April 29, 2016

**RE: North I-25 Corporate Center (File: B18D001)**  
**Amended Drainage Master Plan**  
**Engineer's Stamp Date: 3-3-2016**

Based upon the information provided in your submittal received 3-4-16, the above referenced plan cannot be approved until the following comments are addressed:

**PROPOSED BASIN MAP**

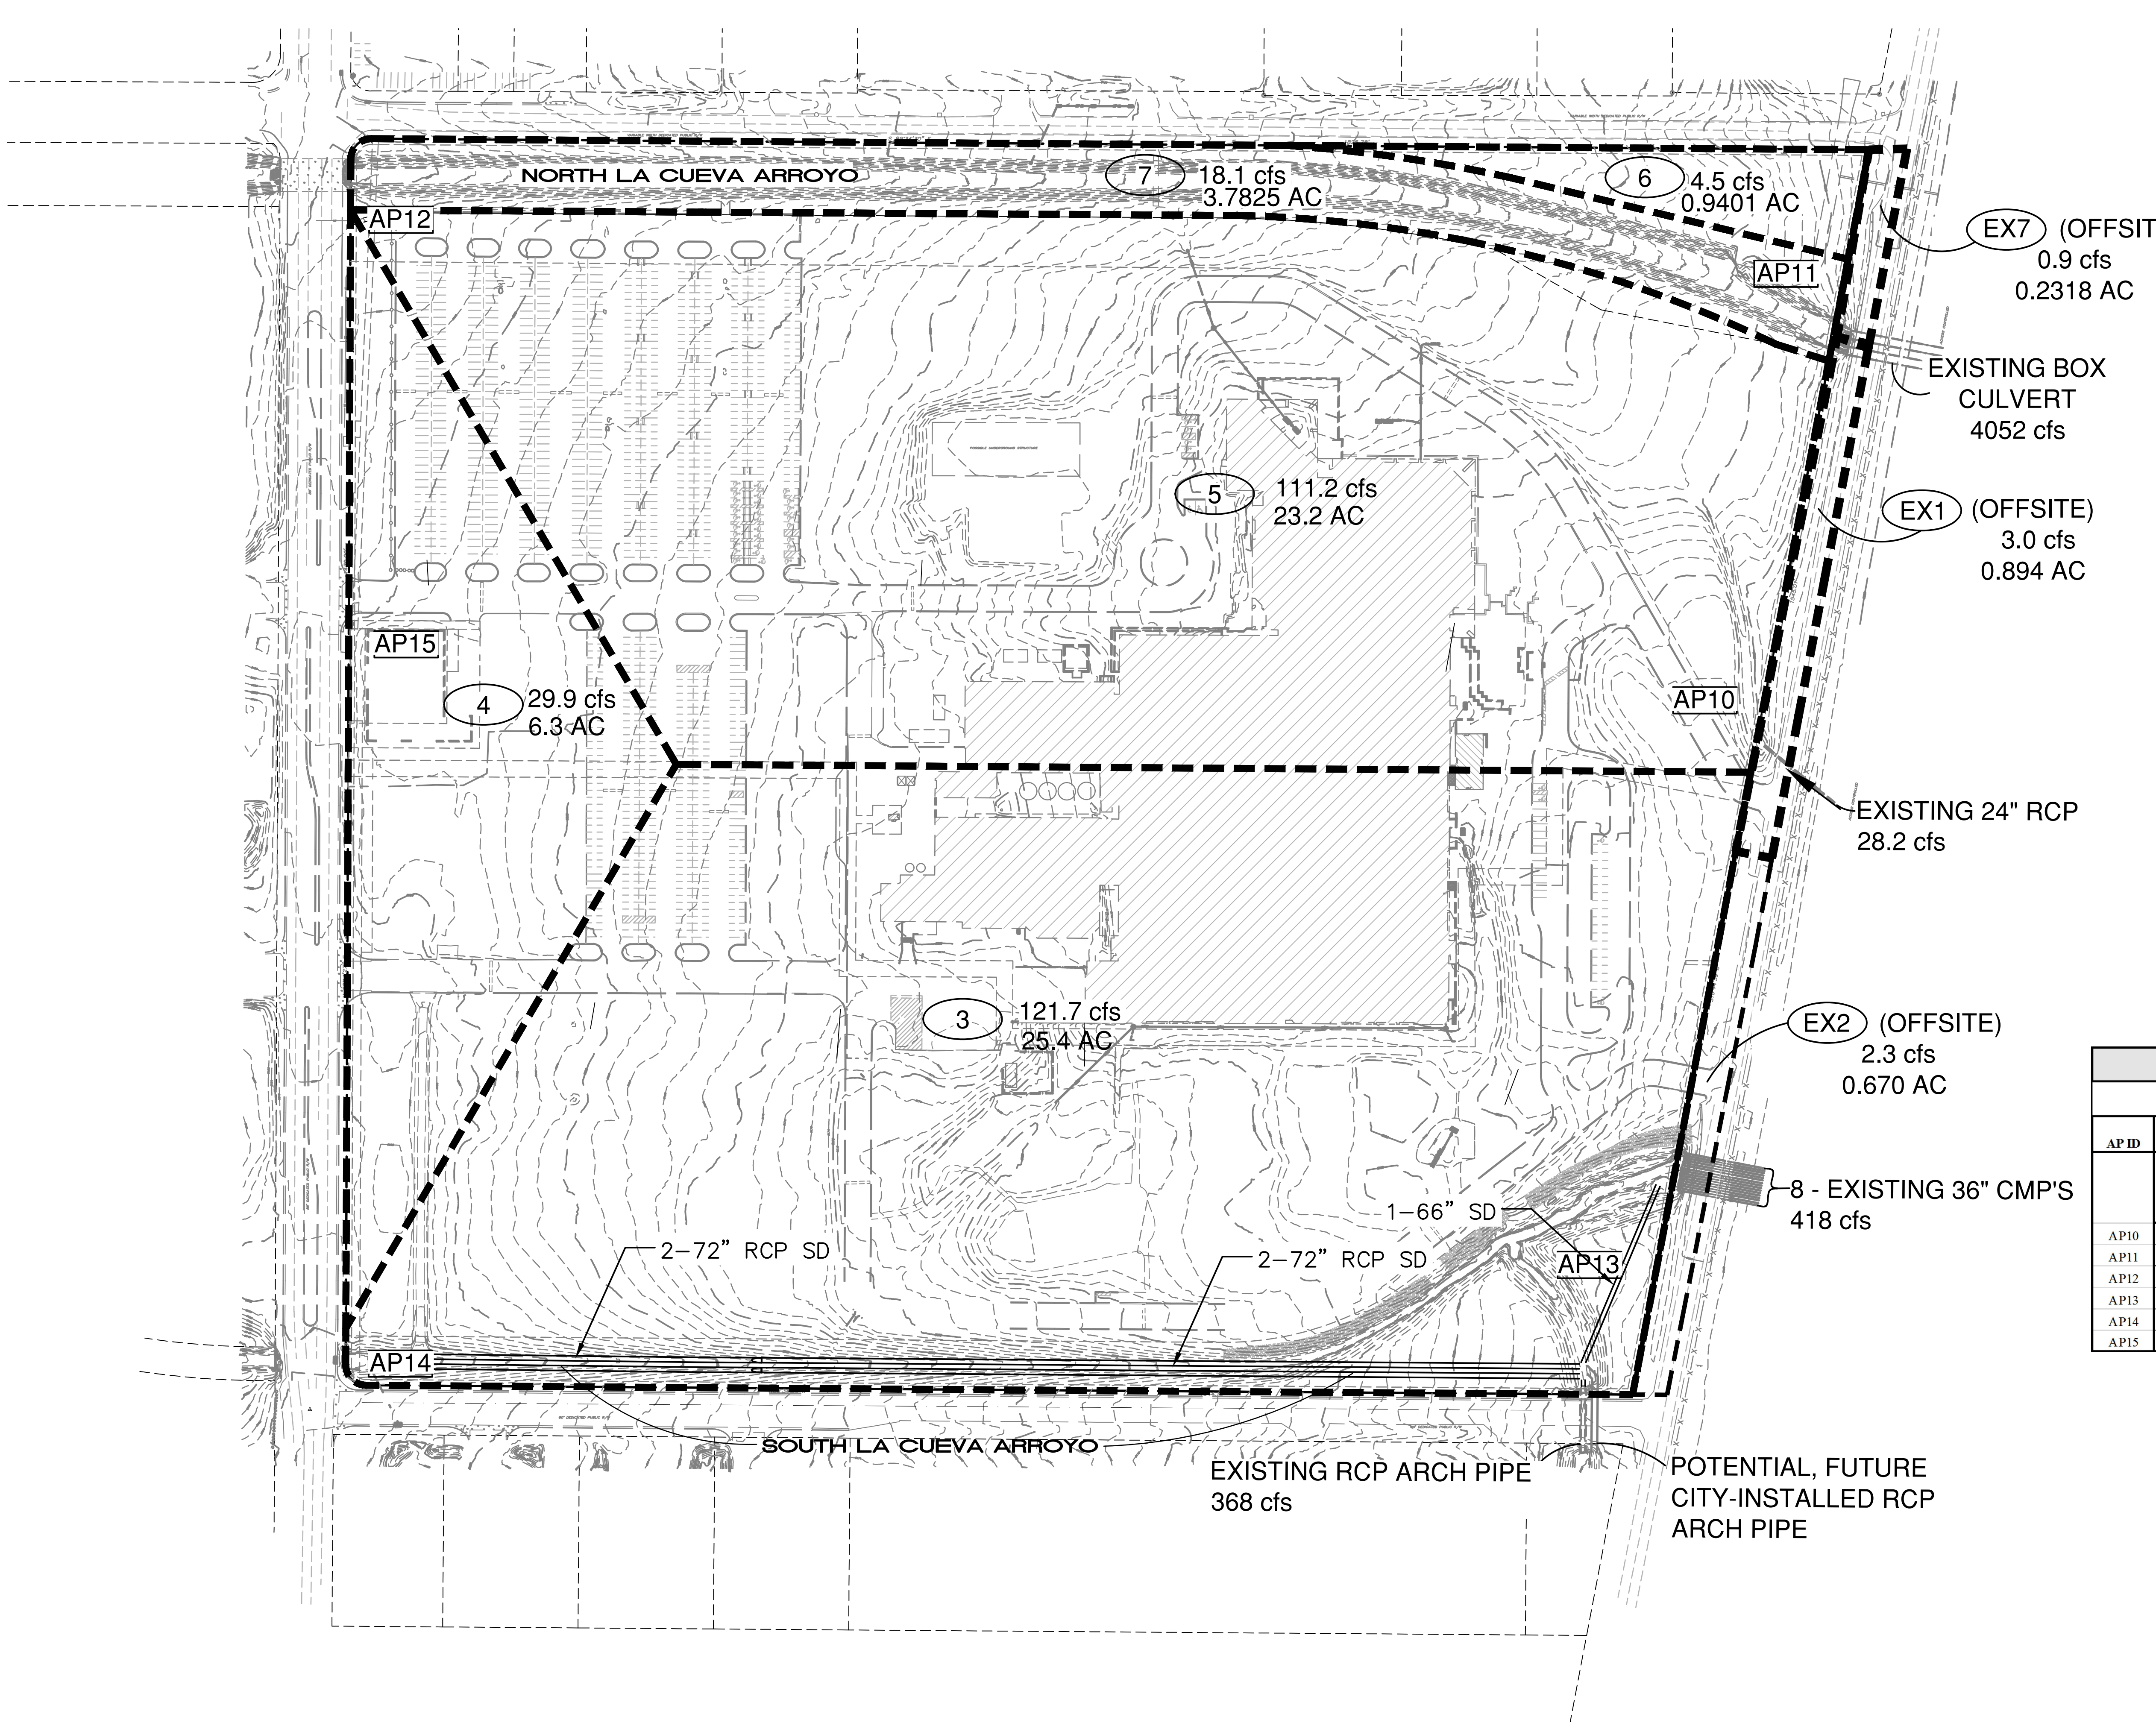
3. Basin boundaries should be modified to match those shown on Northpoint Townhomes.
4. Show the High Point in San Mateo, to show that no offsite flows are directed to inlet over channel.
